Address: 62 Clumber Drive Cleckheaton BD19 4RP

Application number: 2024/91451	
What is the application for?:	Erection of detached dwelling with associated external alterations and erection
Address of the site or building:	88, Shirley Road, Gomersal, Cleckheaton, BD19 4ND
Postcode:	BD19 4ND

### Proposed Attic Floor Plans

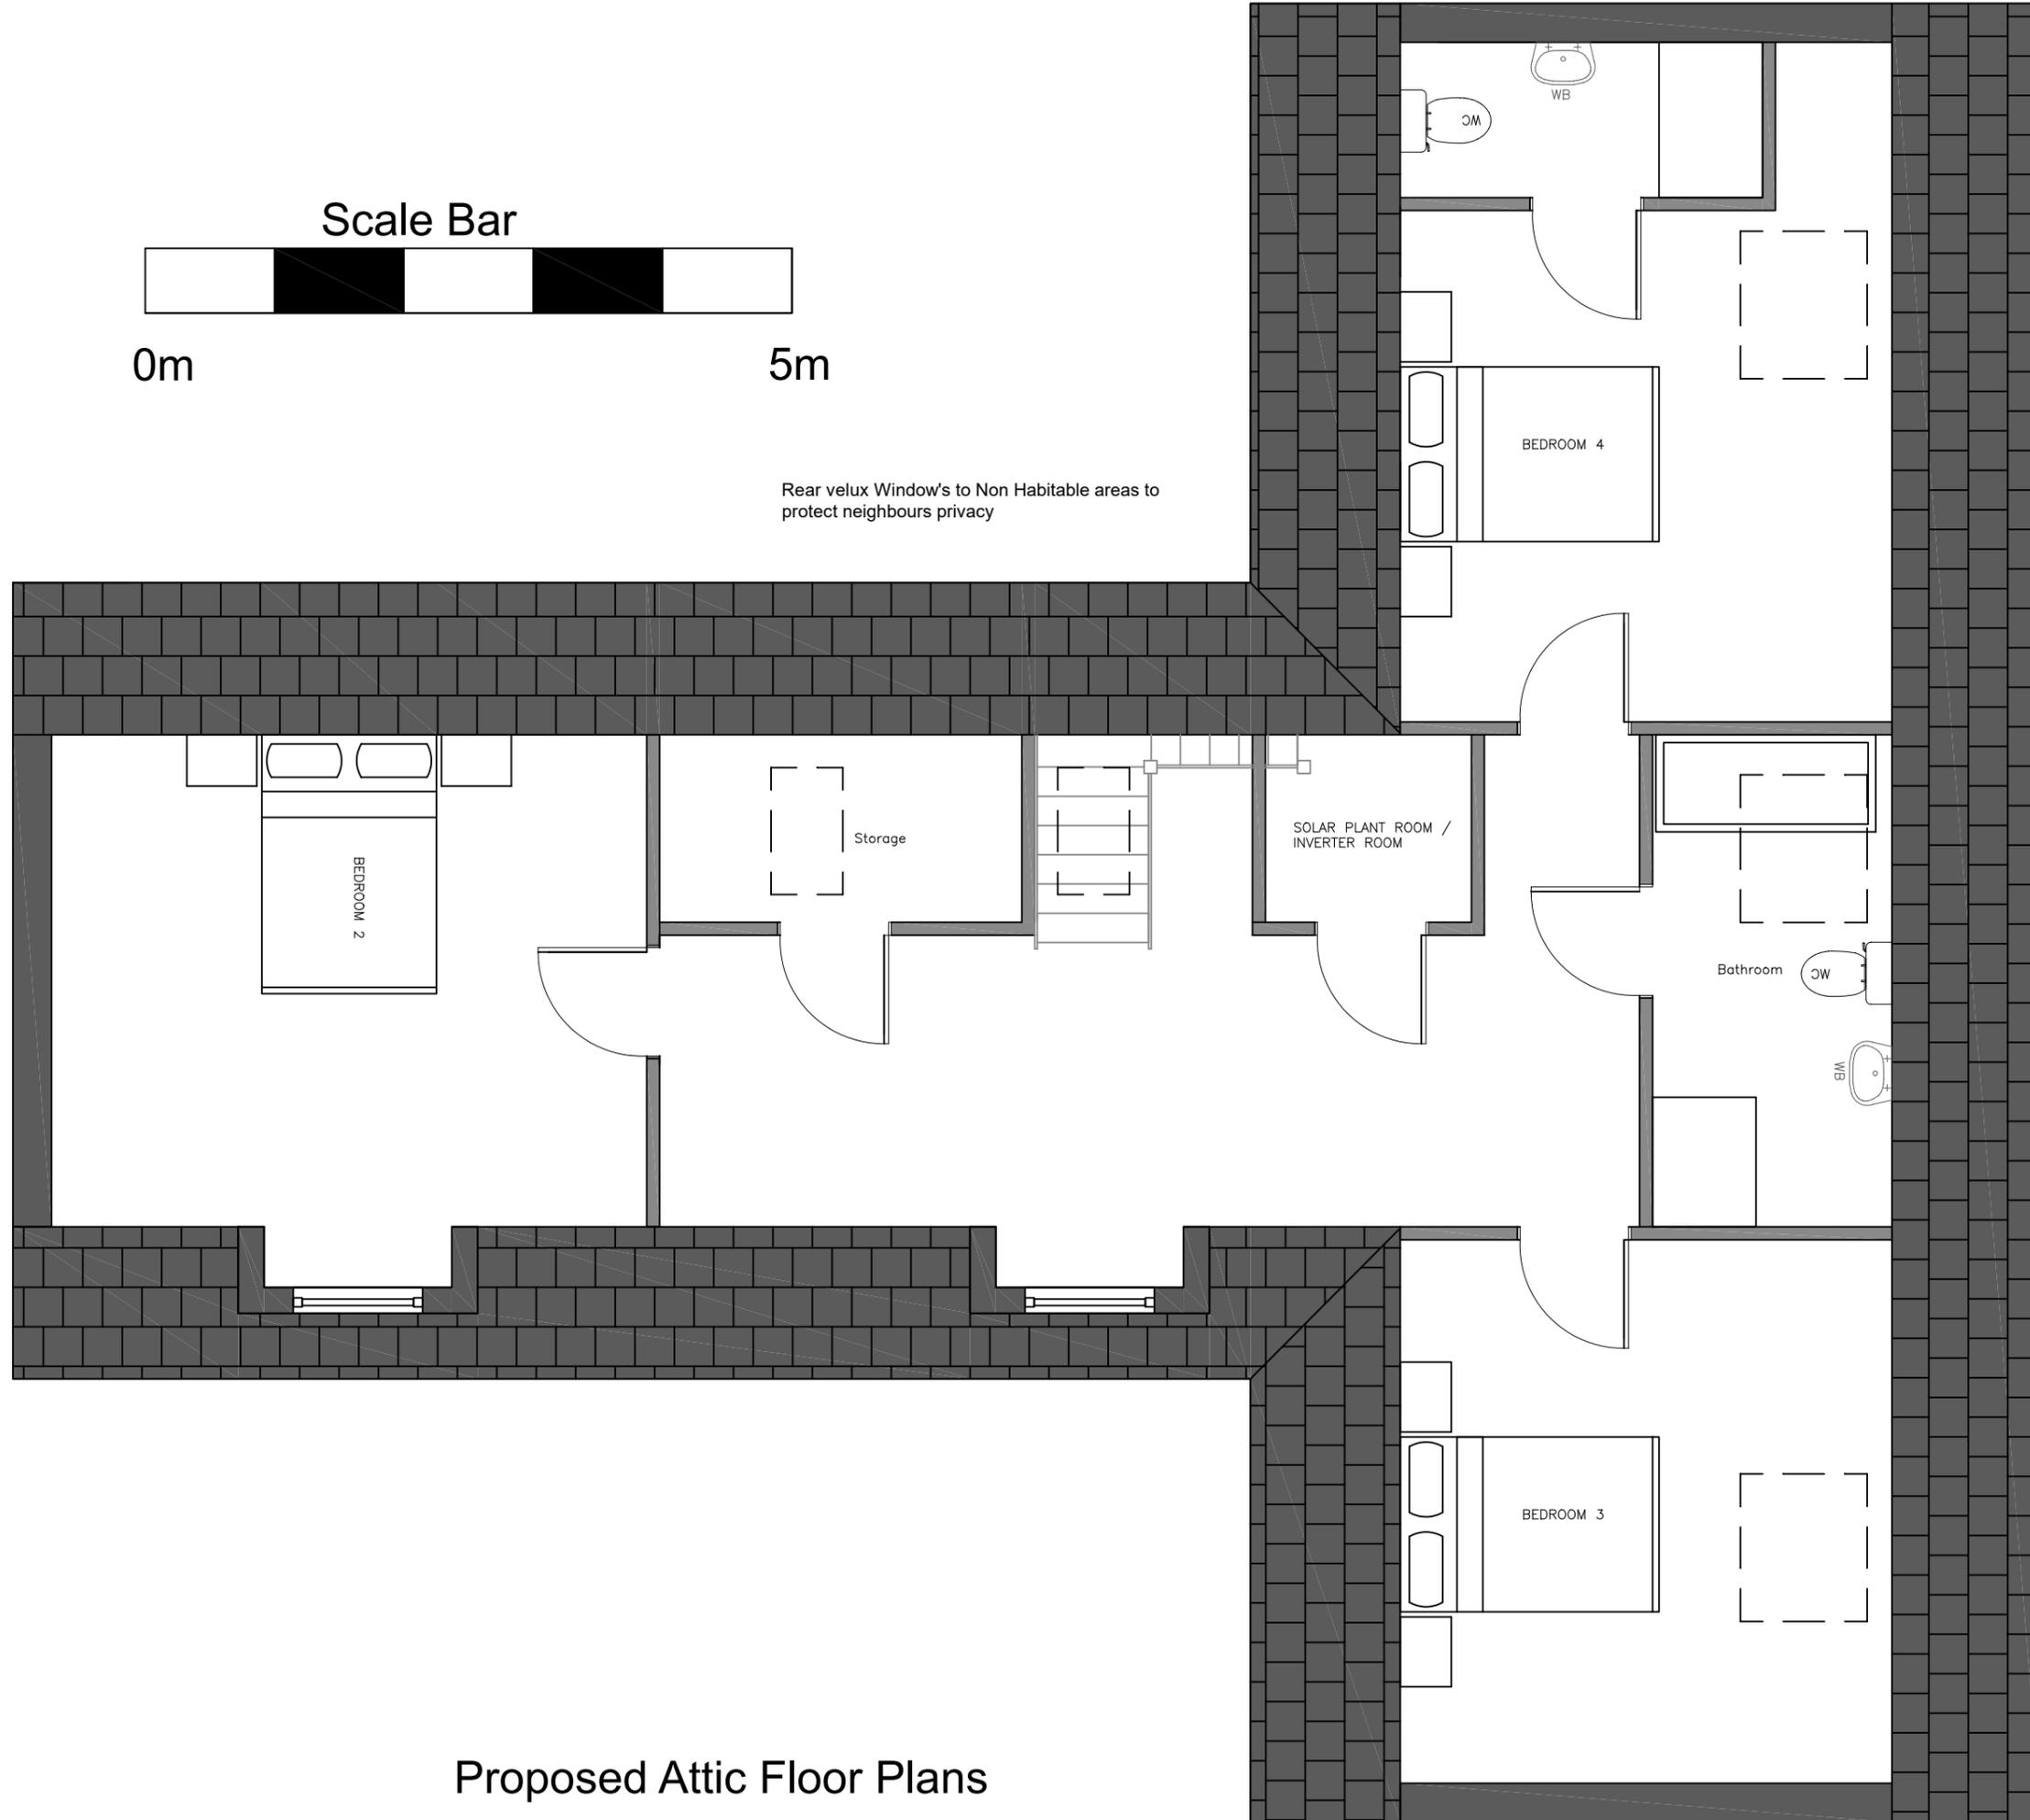
Type of comment: A general comment	
Do you wish your comments to be published on the website anonymously?	No
<p>After receiving a notification letter from the Council regarding the the proposed works we do not have any major objections.</p> <p>Comments and observations are however as follows.</p> <p>a) There are some significant internal changes in the proposals for the works to the existing property from the layouts in the previous agreed planning application.</p> <p>b) Working hours &amp; environmental issues such as noise, smoke etc need to be properly managed so as to minimise any inconvenience to surrounding property owners. This needs to be applicable whether a self build or contractor build route is undertaken.</p> <p>c) We would request that the front elevation first floor windows are replaced with Velux rooflights (same as rear &amp; side elevations). This would protect visual amenity and privacy.</p>
